Reference: KBC/21/012
Date: 19th October 2021

Address: Vrindhavan, Ash Road, Hartley. DA3 8EY

Proposal: Planning application for removal of front porch and bay windows, removal of side chimney and removal of front dormer. New front porch, two storey side extension and part single part two storey rear extension

Front Elevation
As Proposed

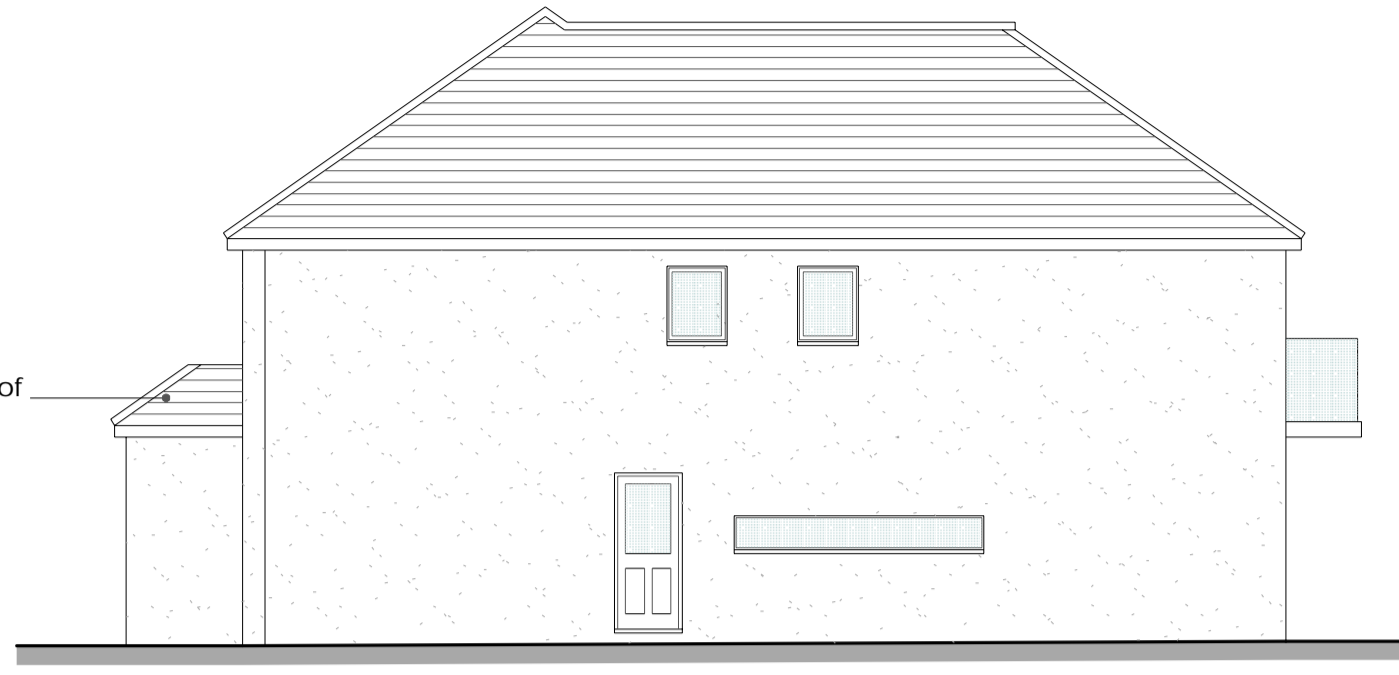
Planning permission was refused on the 11th October 2021 under application reference 21/02760/HOUSE. Reviewing the officer report it appears that the refusal was due to the balconies to the front elevation of the property. We are submitting revised drawings to address this issue. The balconies to the front elevation have been removed and the doors and windows to the front bedrooms updated to show a traditional window arrangement.

Ground Floor Plan
As Proposed

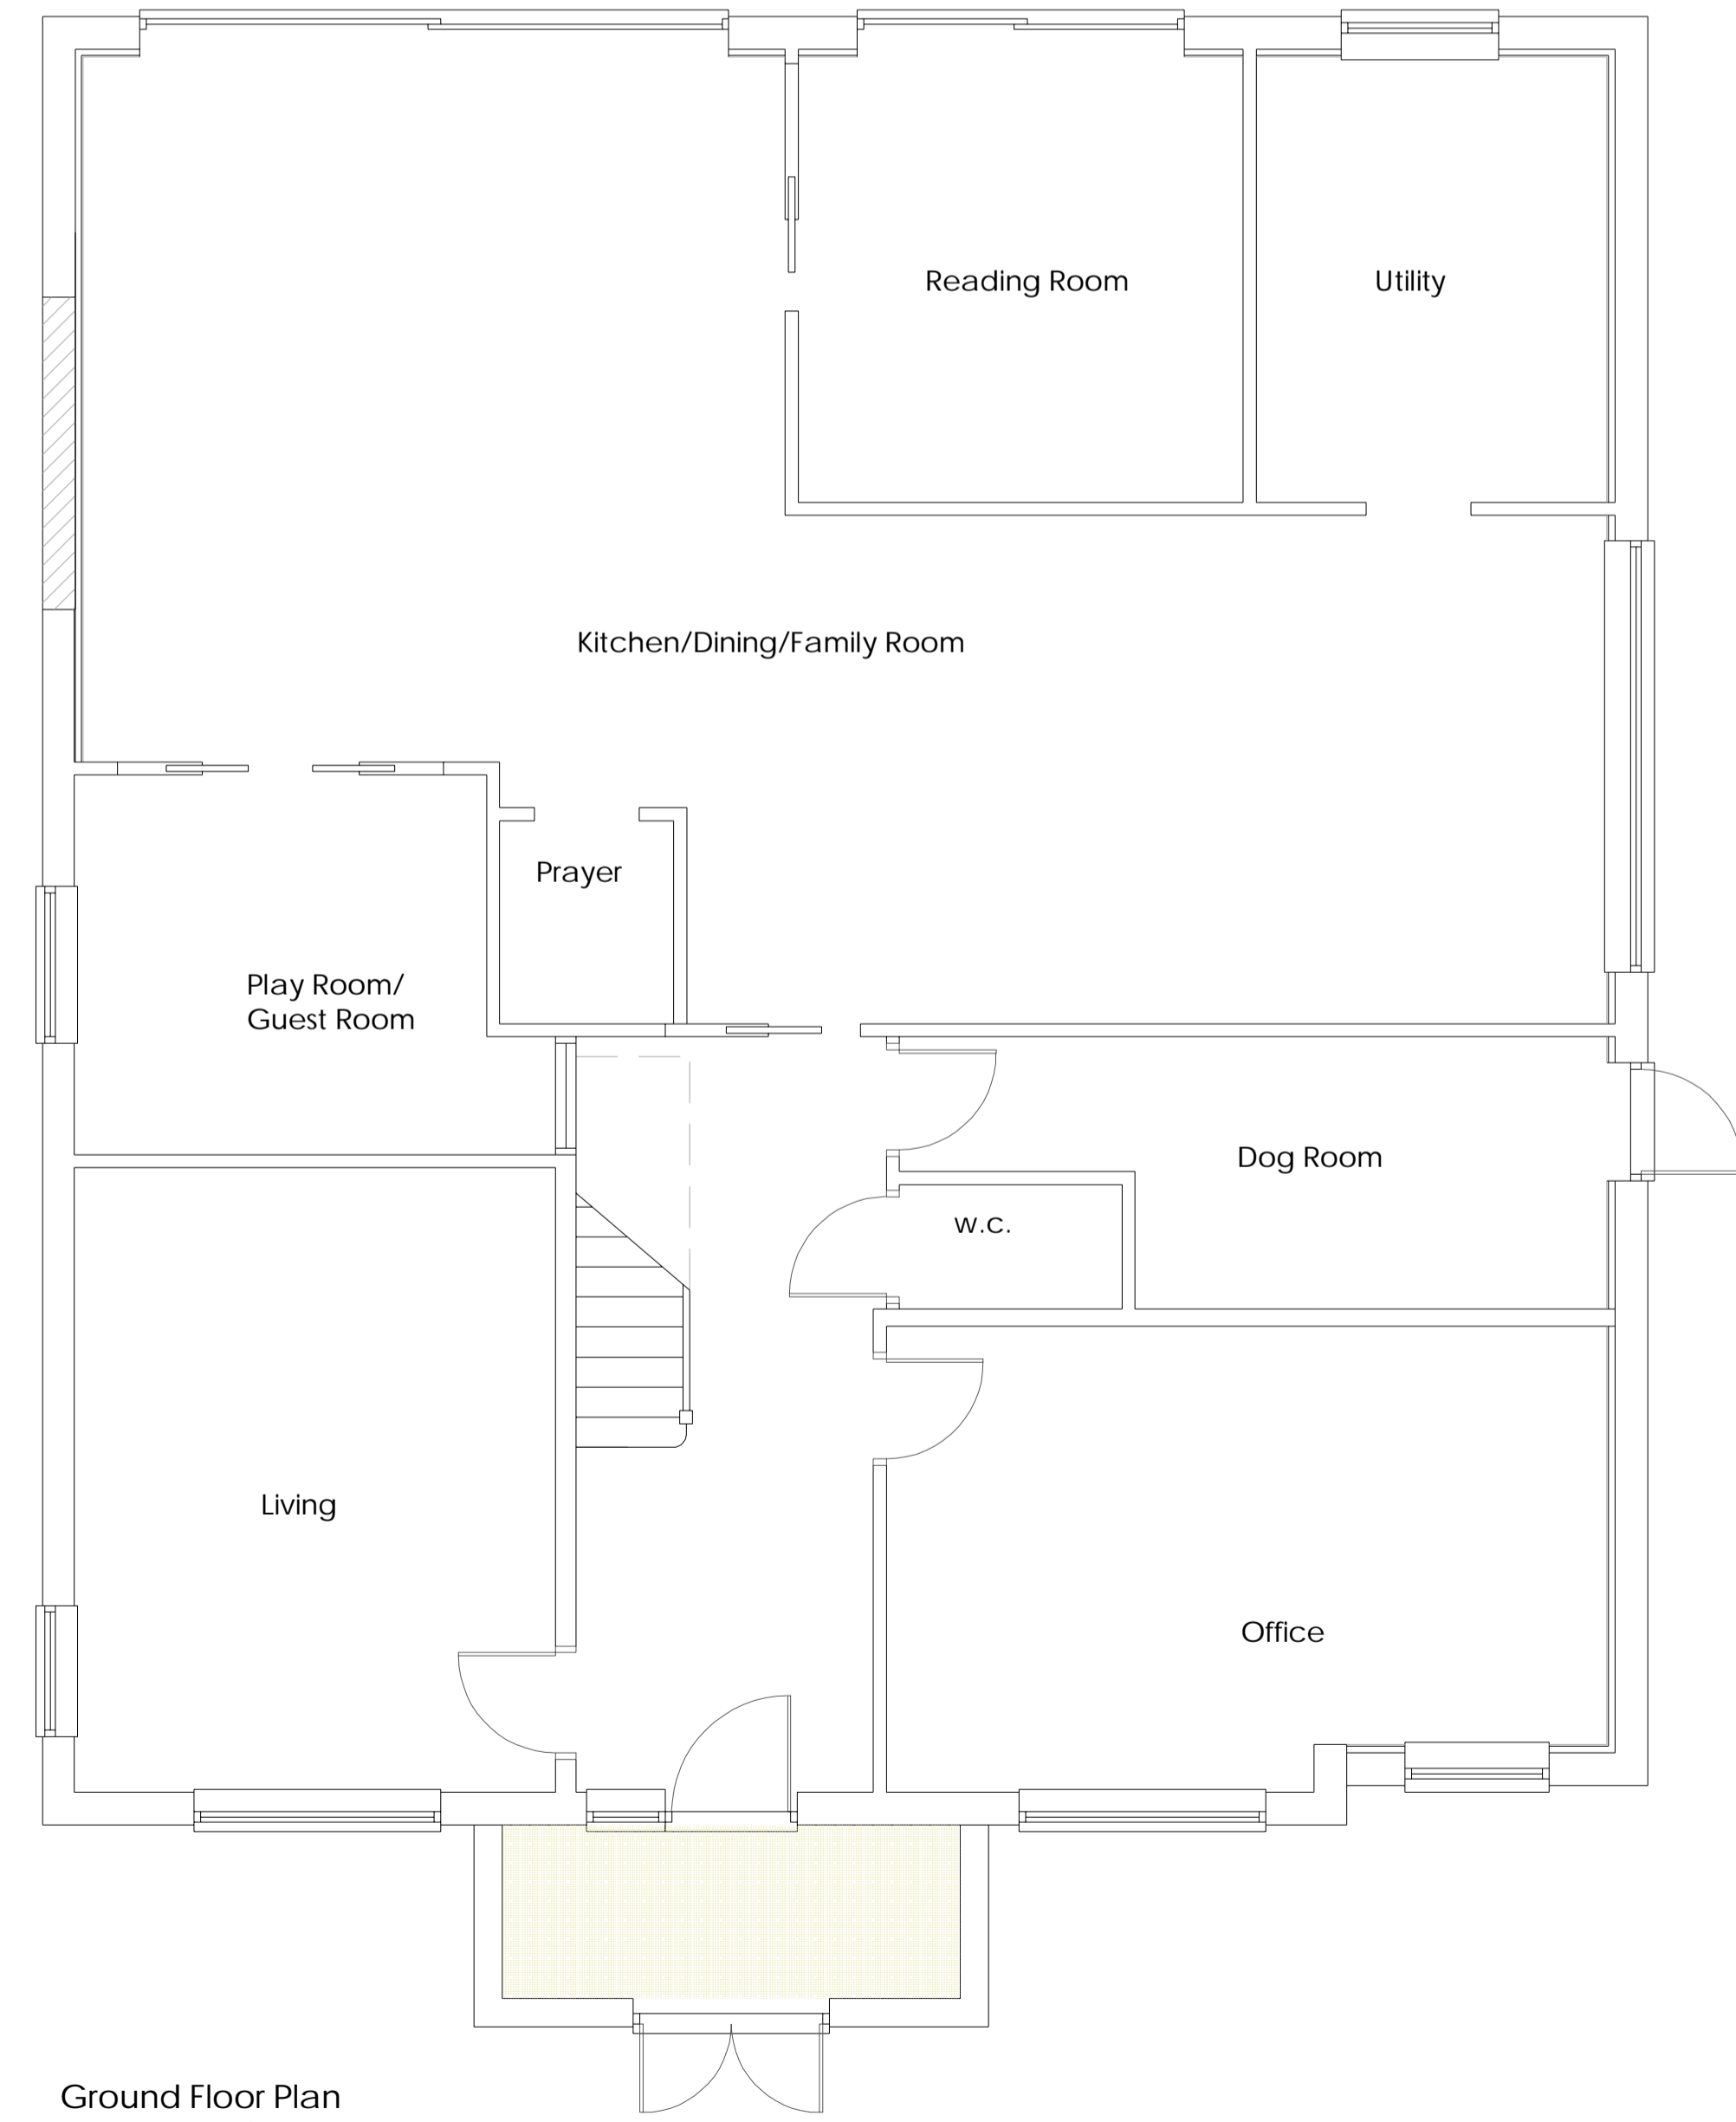
The officer report also provided the floor area calculations under the green belt policy. The calculation noted the increase to the area to 48% of the original building. We have updated the floor plans to have the side wall running straight through the entire length of the side elevation. This will increase the floor area by 2.96m² which will still be below the 50% allowed.
